From: Simon Davis <Simon.Davis@arun.gov.uk>
Sent: 19 December 2019 10:08
To: Planning.Responses <Planning.Responses@arun.gov.uk>
Subject: FW: Inglenook Hotel Planning Ref P/58/19/PL

Further Pagham Parish Council response

Having considered the changes proposed by the developer in respect of this application, the Parish Council still OBJECTS to the scheme and would like to make the following comments:

Refuse Vehicle
Swept Path Analysis

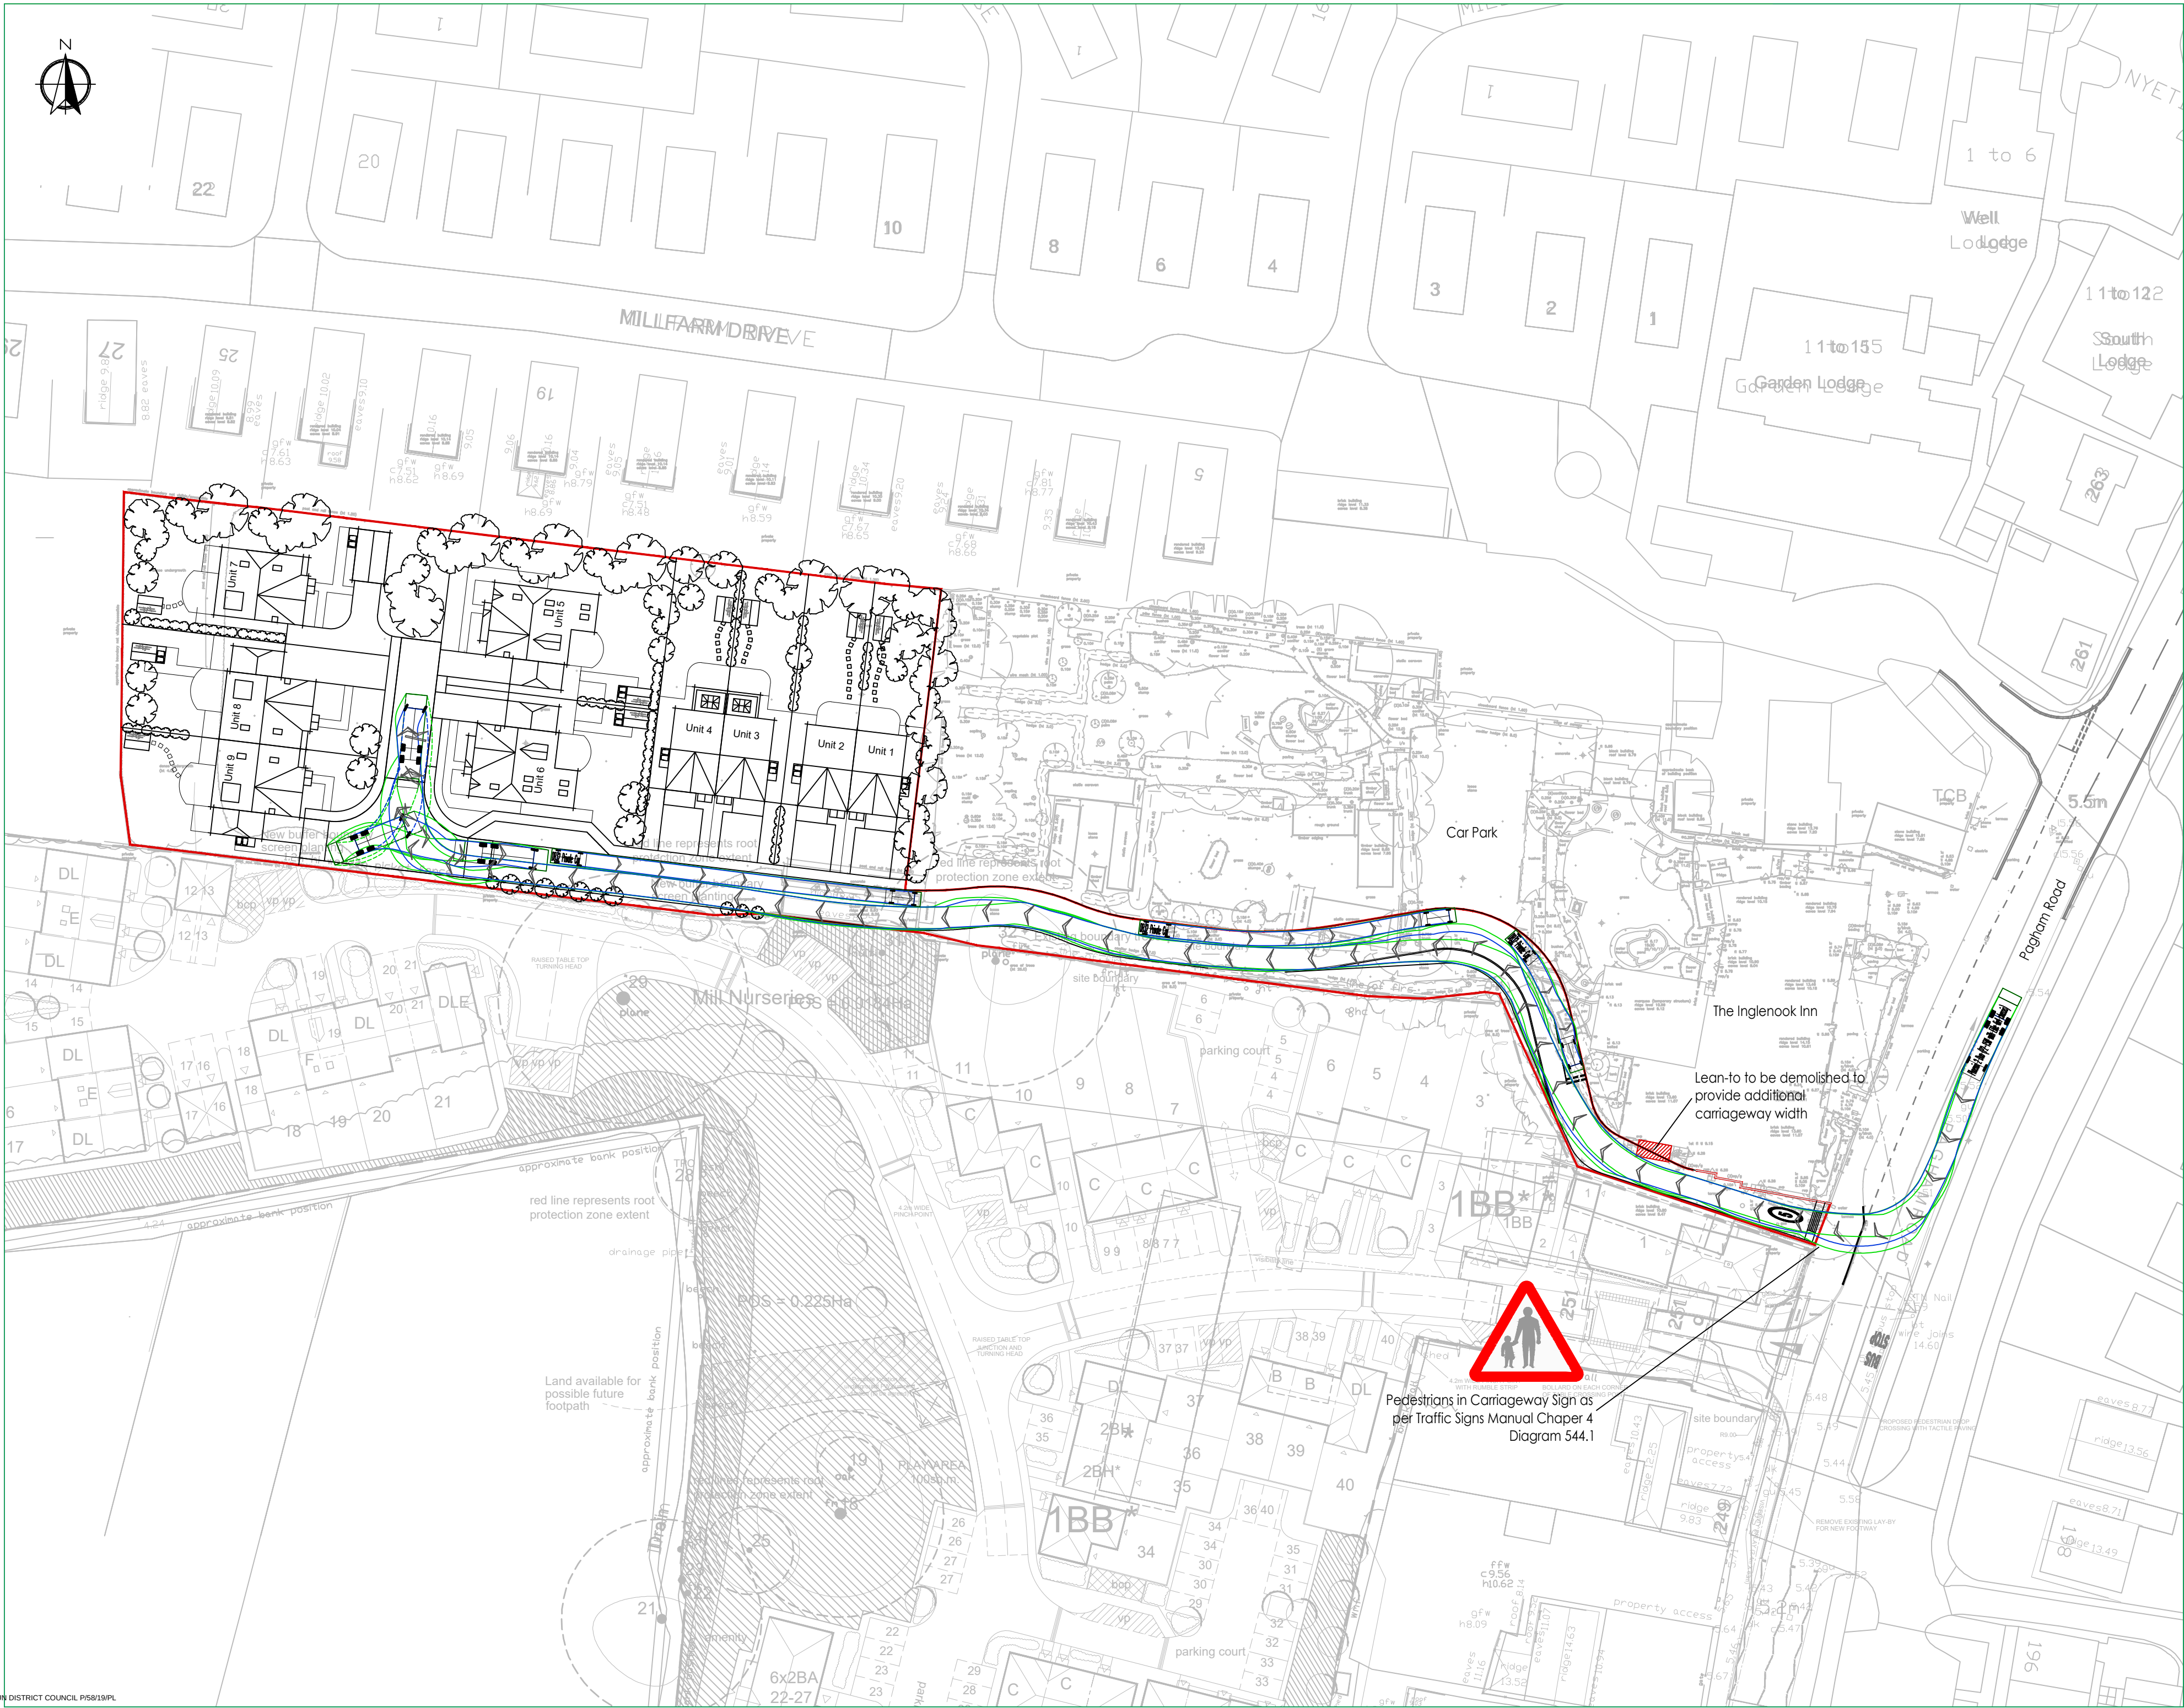
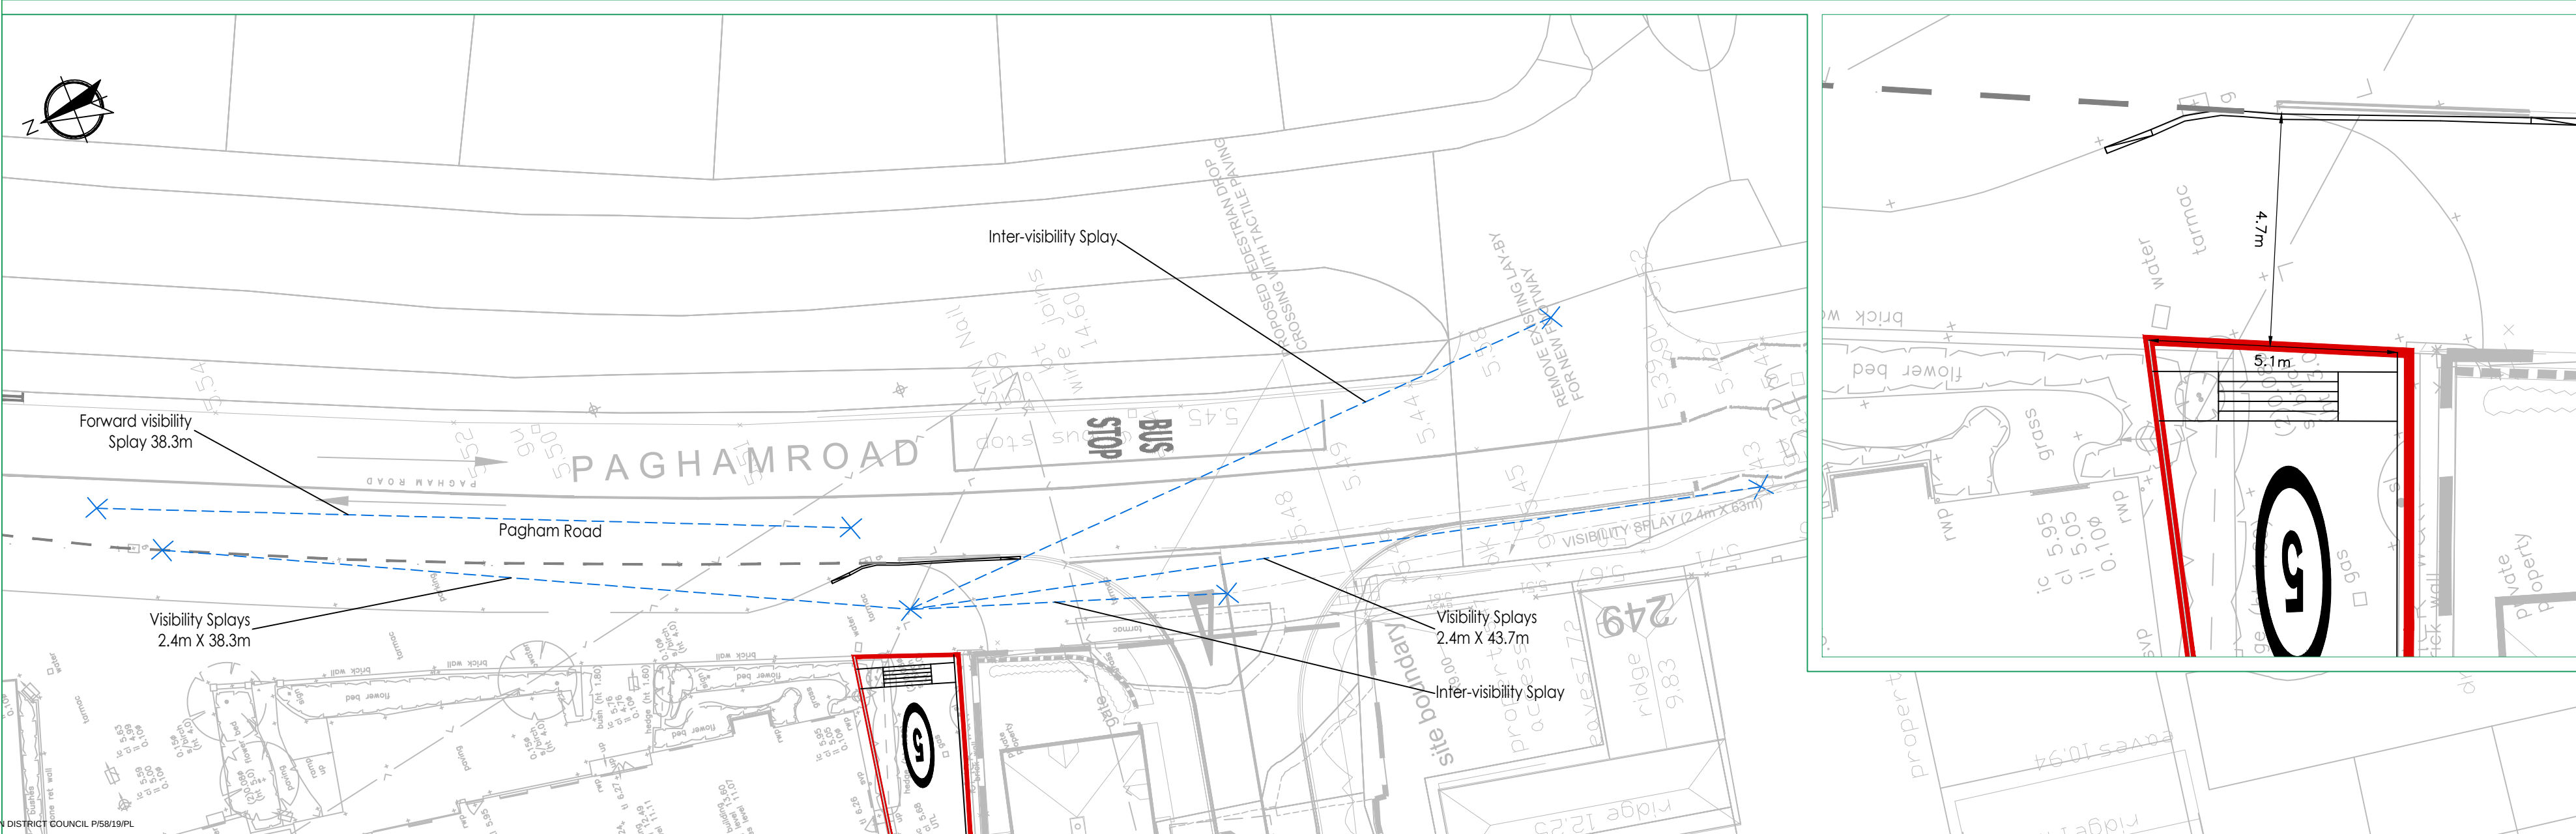
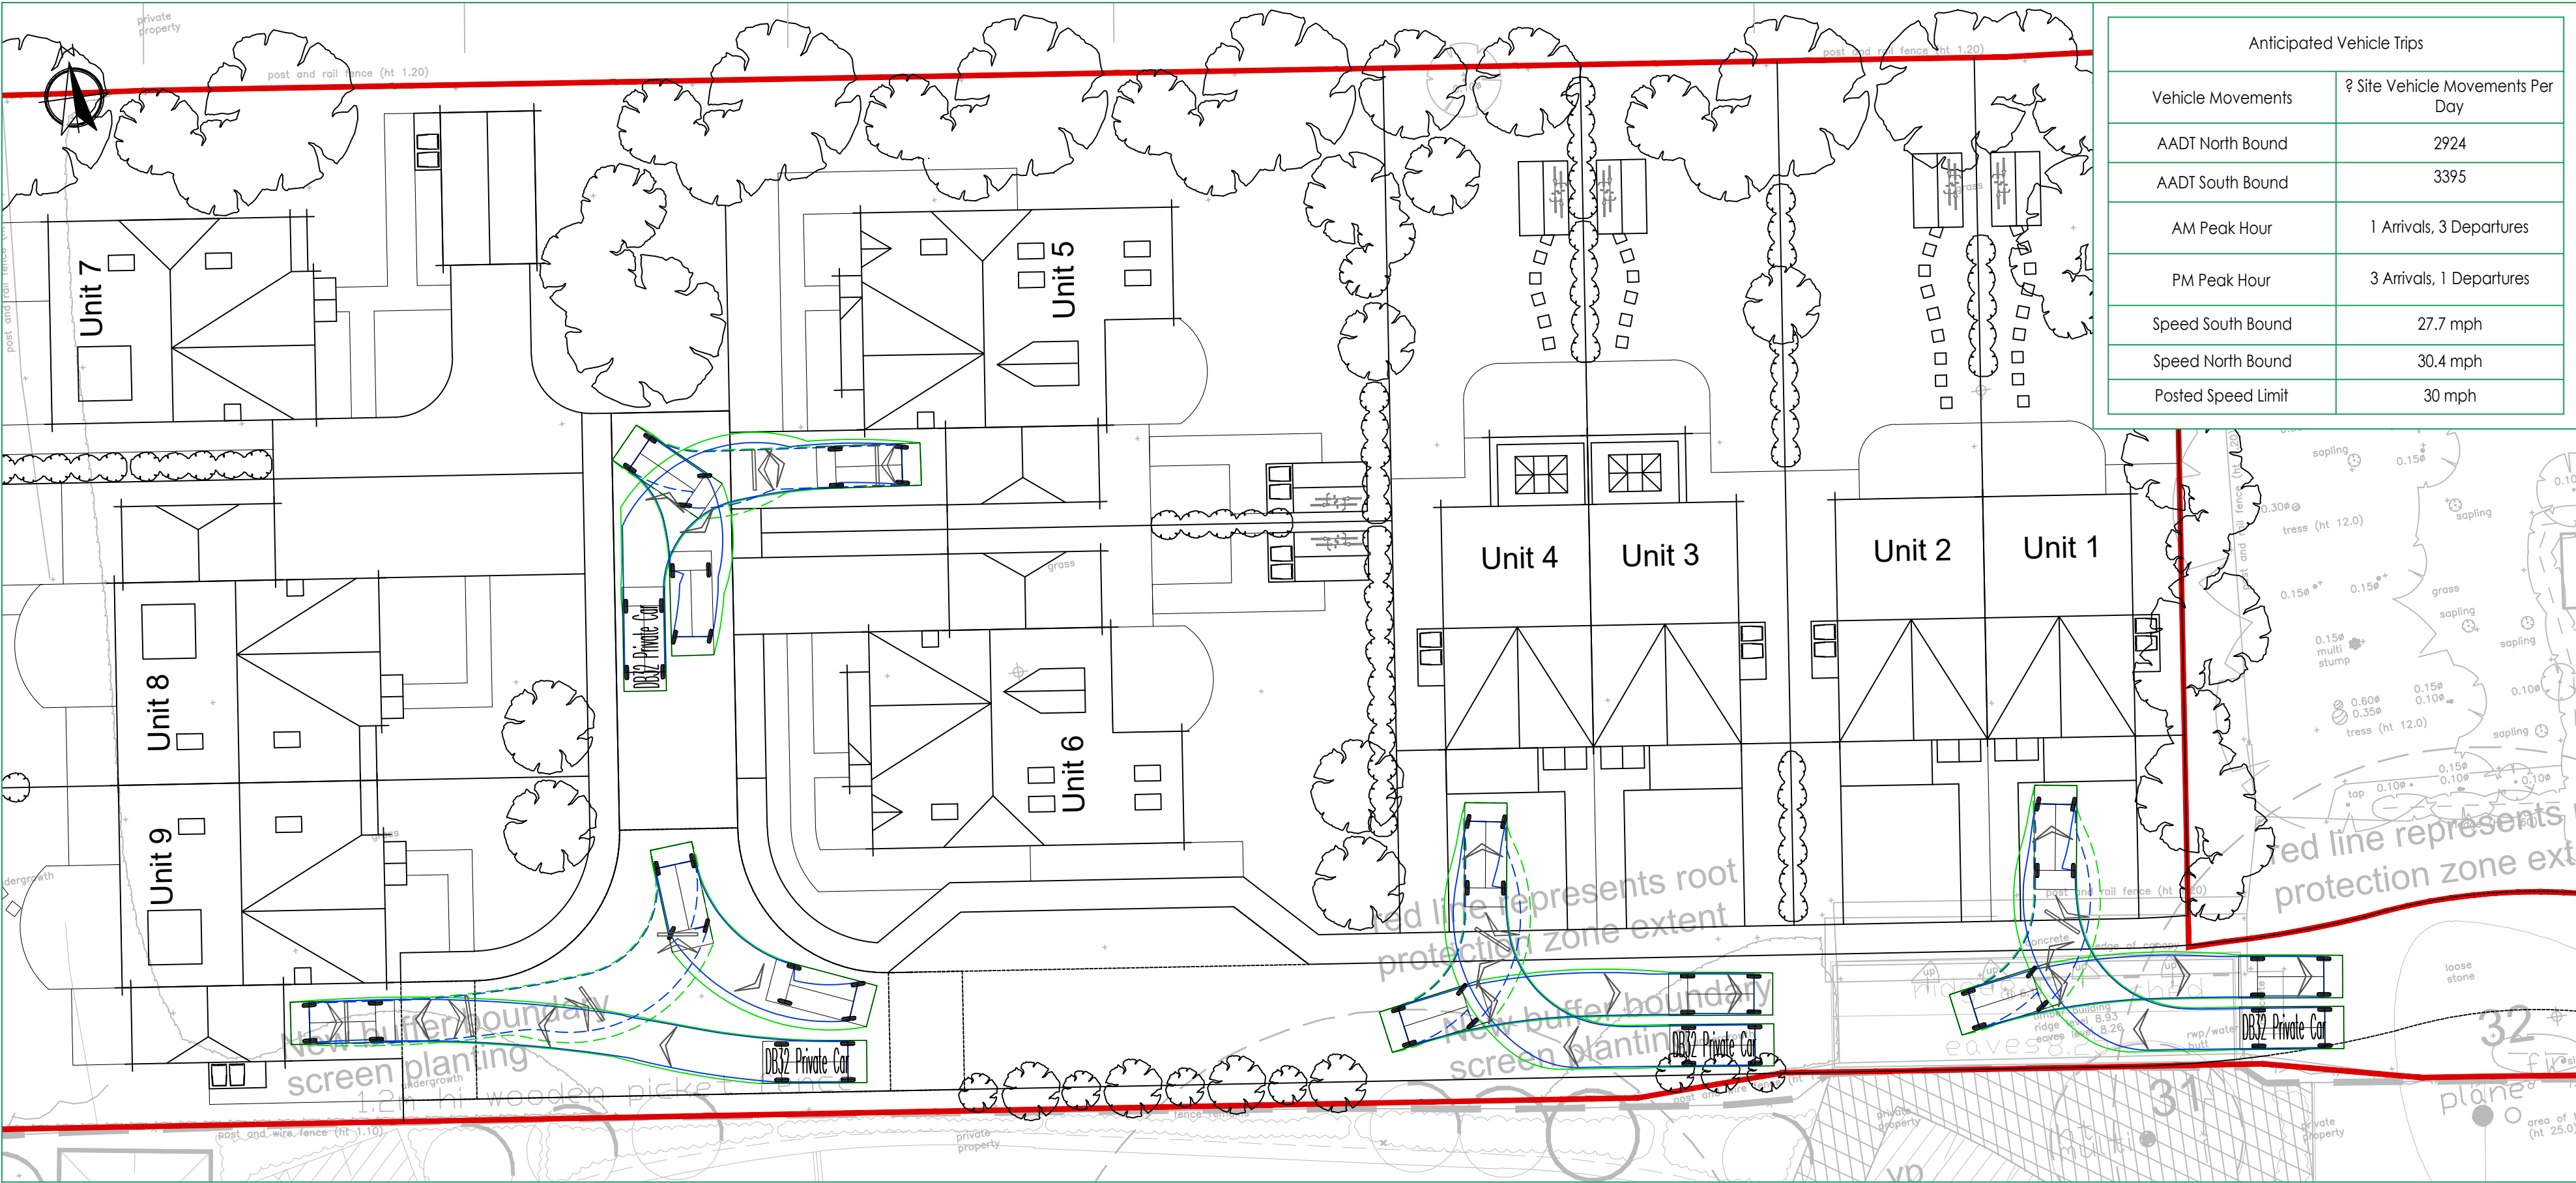
Providing a bonded gravel pavement does not solve the issue that the driveway is not wide enough for pedestrians and vehicles to use it safely. Even with signage to warn of other vehicles and pedestrians in the road, inevitably the vehicle entering from the Pagham Road would be the vehicle to reverse if two vehicles were using the road at the same time. Having a delineated space for pedestrians will not stop vehicles using it, leading to further rather than less danger as pedestrians assume they are safe in the designated area whereas the vehicles use both areas. There is no viable way of enforcing this. The signage would need to indicate a warning regarding pedestrians and vehicles. What lighting is proposed for the shared drive?
